From: Parish Clerk Billington and Langho Parish Council
<parishclerk@billingtonlanghopc.org>
Sent: 01 September 2025 13:18
To: Planning
Subject: 3/2025/0540

With reference to application 3/2025/0540 could consideration be given to any overlooking issues.

sheet name:
Proposed Second Floor and Roof Plan

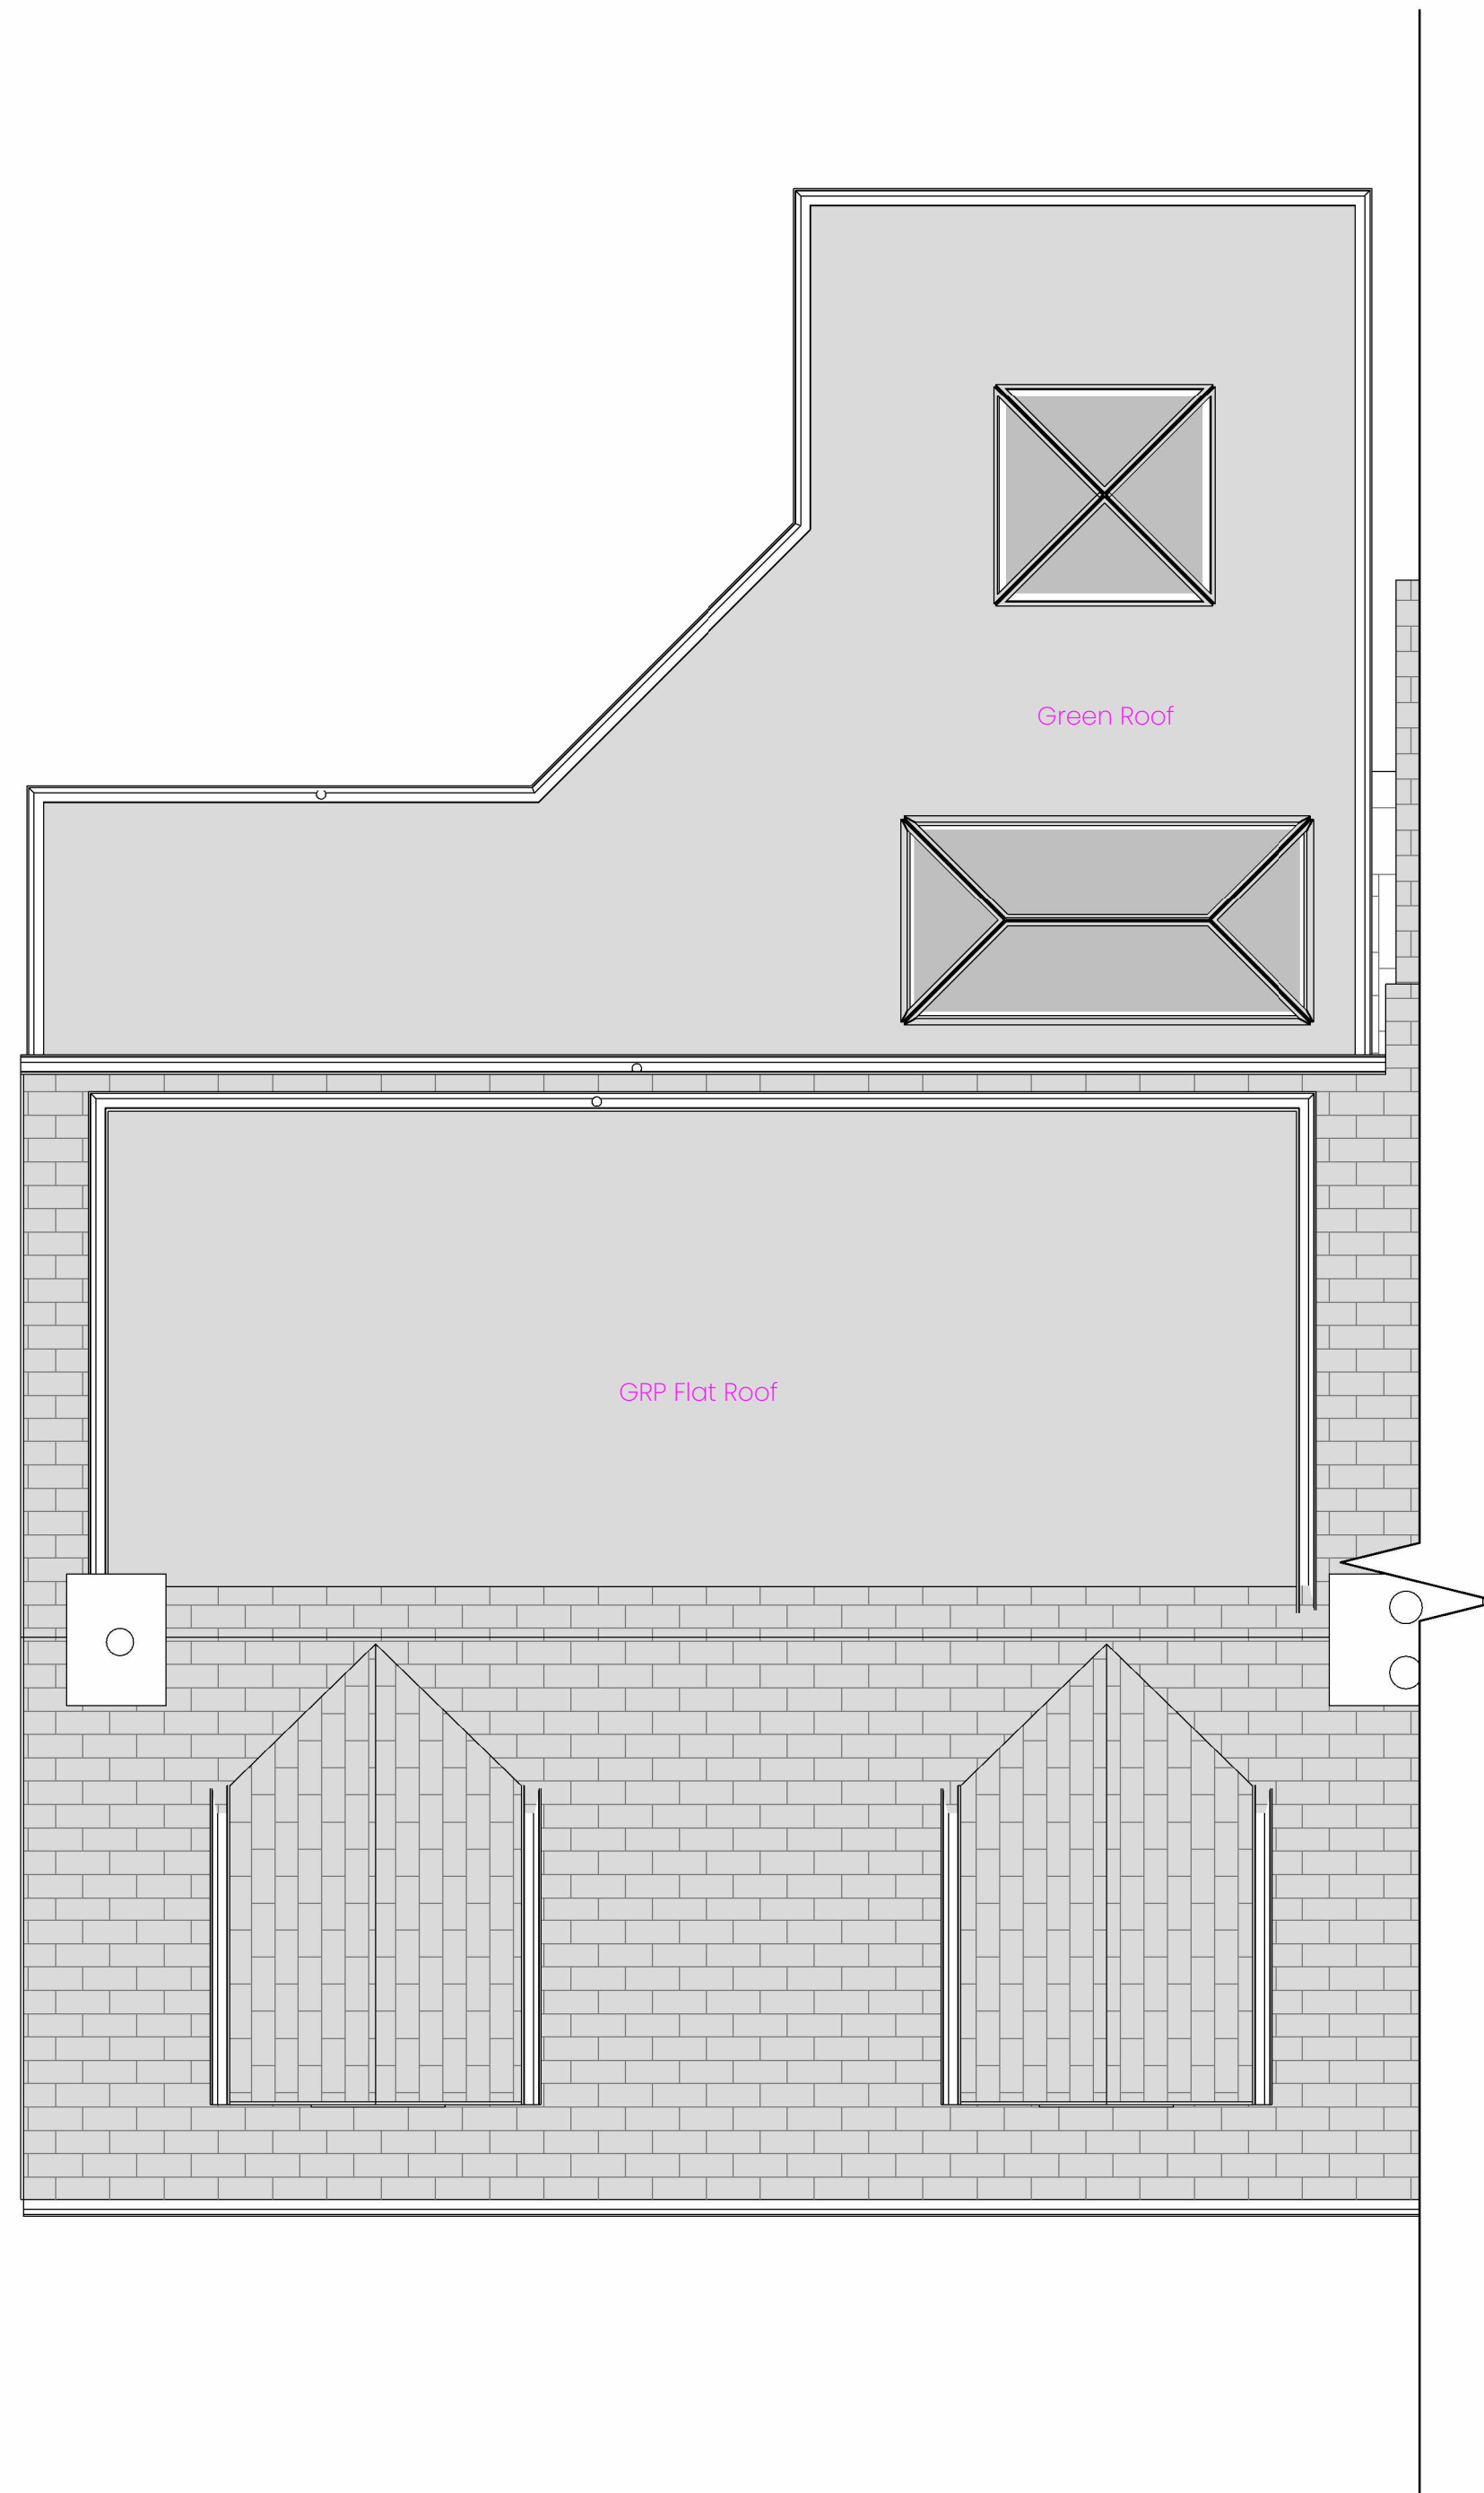
The application site is on the steep slope part of Longworth Road. There could be some validity in the local resident's objection on the web-site, as the application includes some new dormer windows on the first and SECOND floors.

Would the planners have done or consider doing any geometric tests on how substantial the overlooking is?
